STATE OF NORTH CAROLINA  
DEPARTMENT OF TRANSPORTATION

September 14, 2006

Subject: **Amended application for a CAMA Major Development Permit for the Second Bridge to Oak Island**, Brunswick County, WBS Number 34407.1.1, State Project No. 8.2231201, Federal Aid No. STP-1105(6), TIP R-2245, Work Center 34407.1.1, Brunswick County.

Reference: Letter from DCM Dated September 6, 2006 regarding additional information request.

PROJECT REFERENCE NO. R-2245	SHEET NO. 7
RDW SHEET NO.	HYDRAULIC ENGINEER
ROADWAY DESIGN ENGINEER	
PRELIMINARY PLANS DO NOT USE FOR CONSTRUCTION

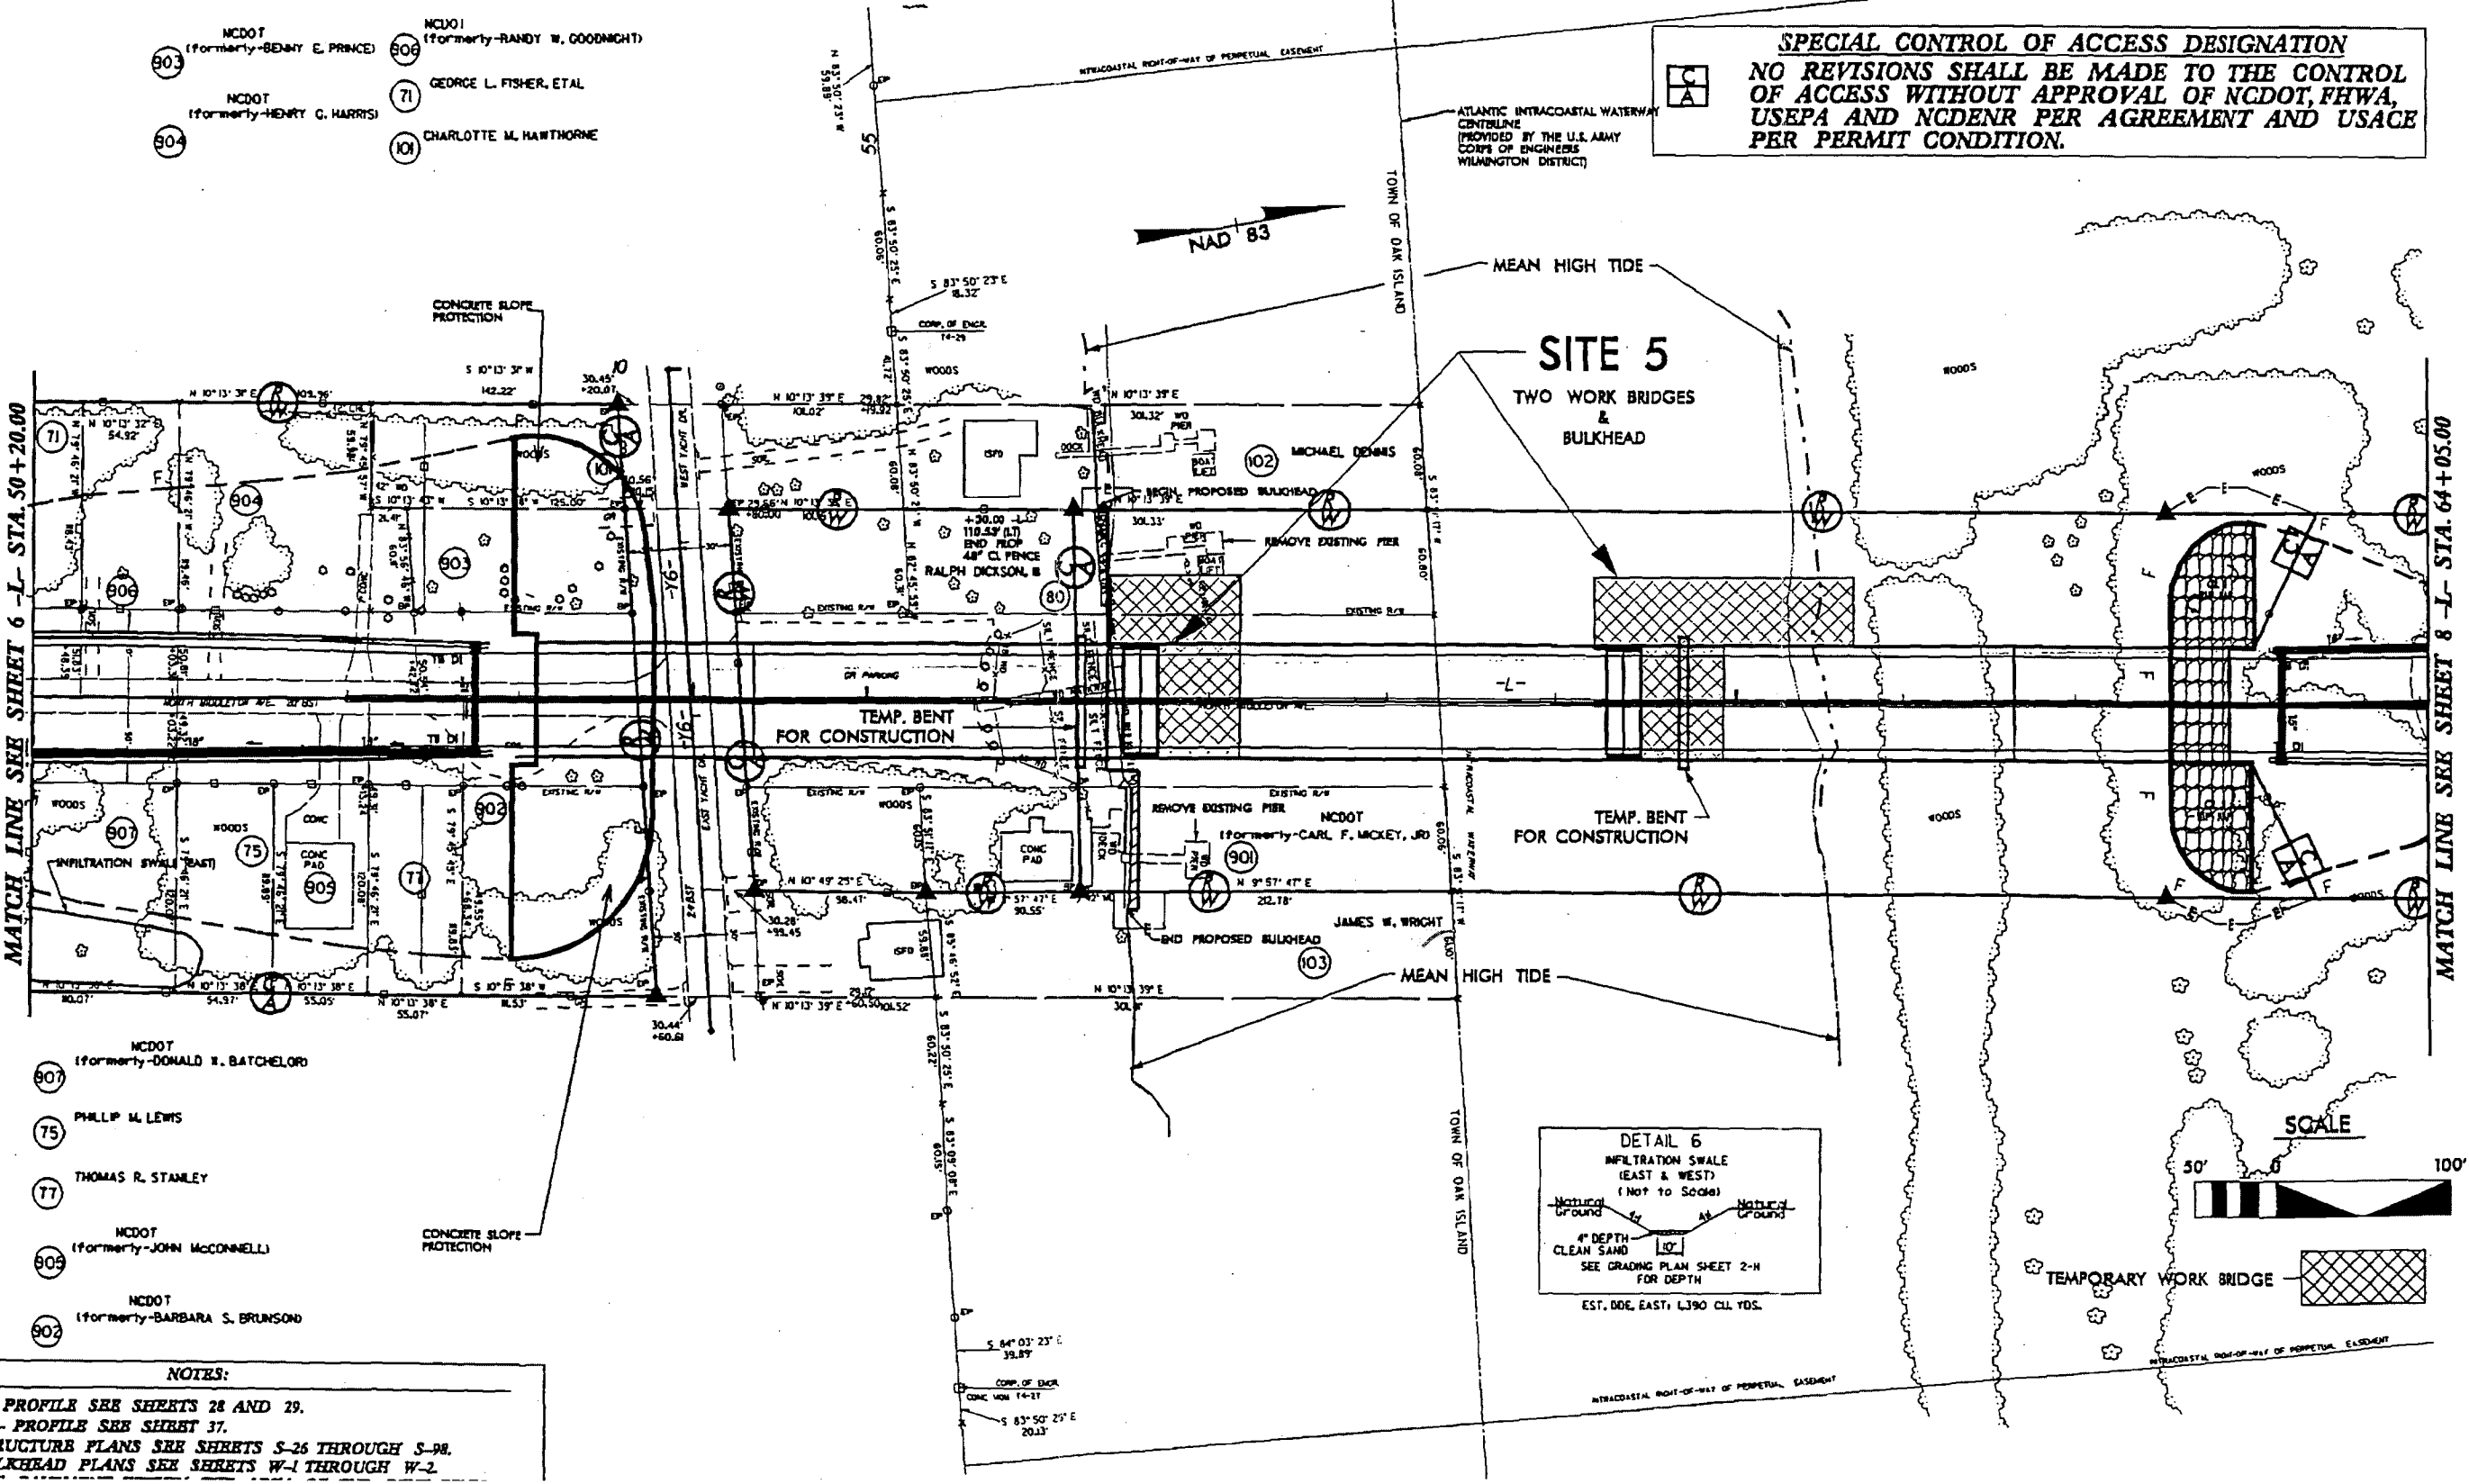
- On Page 15 of the permit application the special access designation on the roadway plans should read “No Revisions shall be made to the control of access without approval of NCDOT, FHWA USEPA and NCDENR per agreement and USACE per permit condition.
